# CITY OF ALBUQUERQUE

November 3, 2015

**Re: Broadstone Promenade Phase 6  
6400 San Pedro Dr. NE  
Grading and Drainage Plan  
Permanent CO – Accepted  
Engineer's Stamp dated: 5-26-15 (D18D054A)  
Certification dated: 10-28-15**

CG1.2

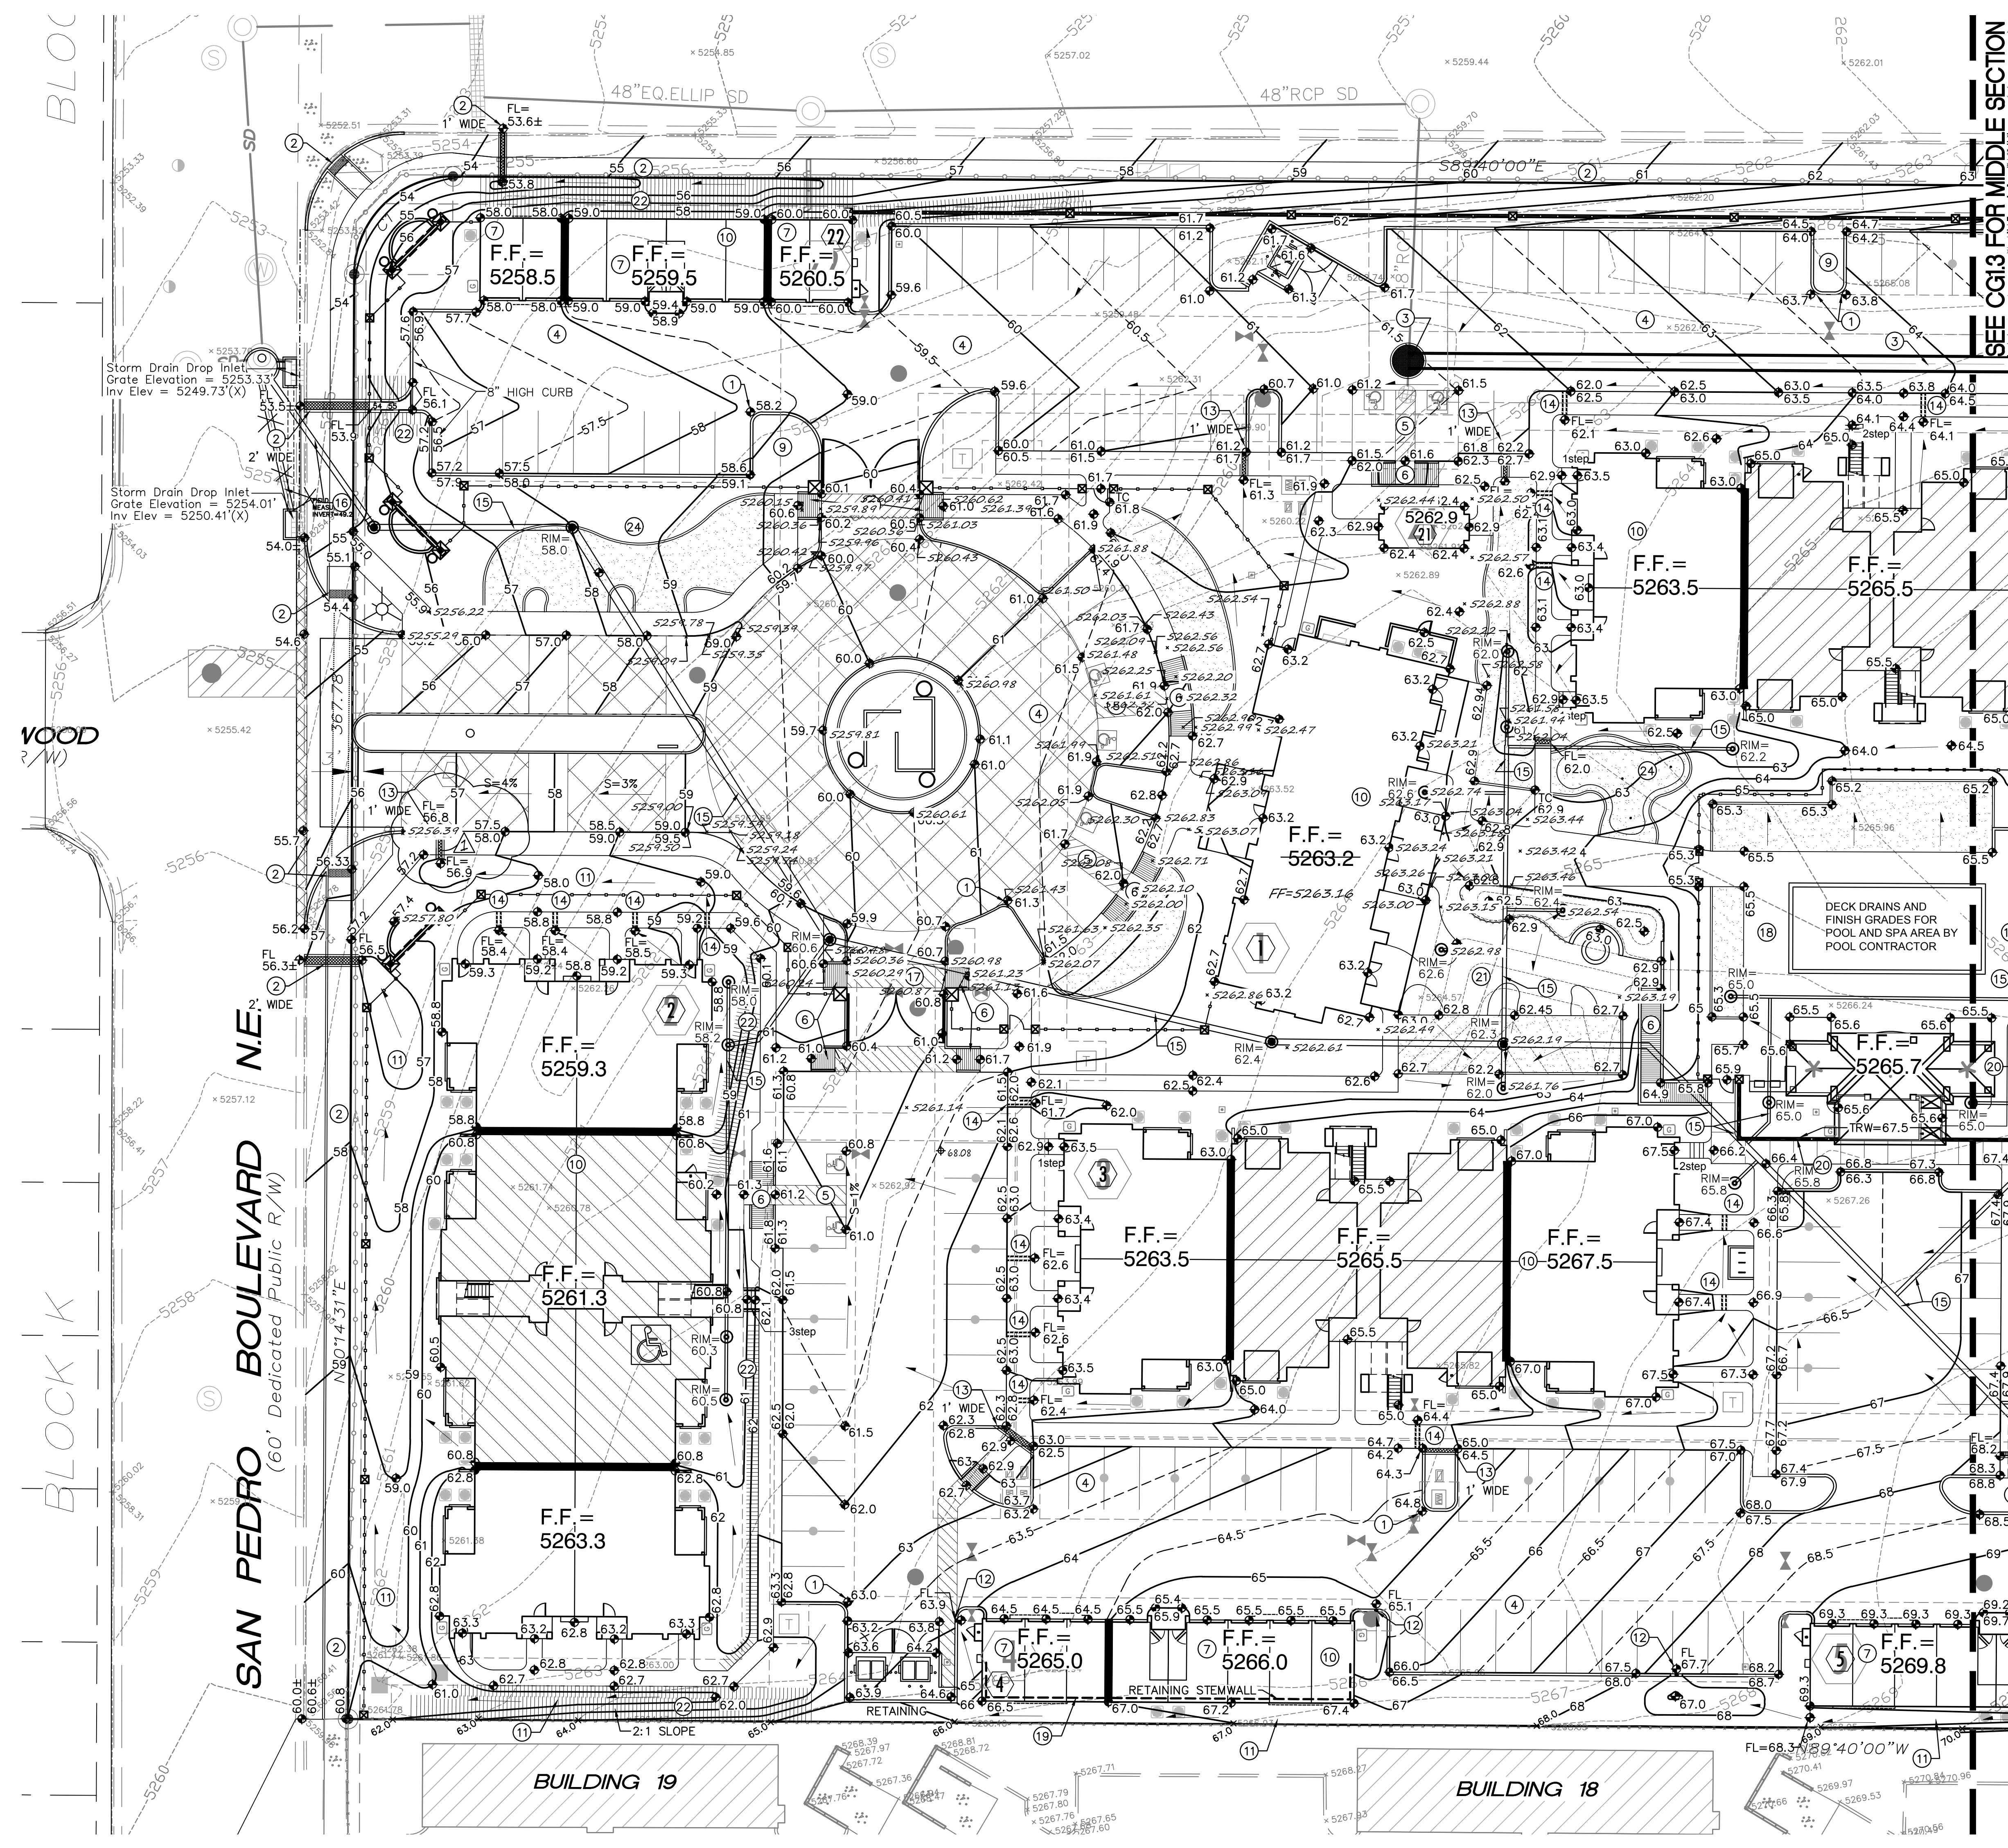
- Make sure swale north of building #2 has positive drainage toward pond at NW corner of building.
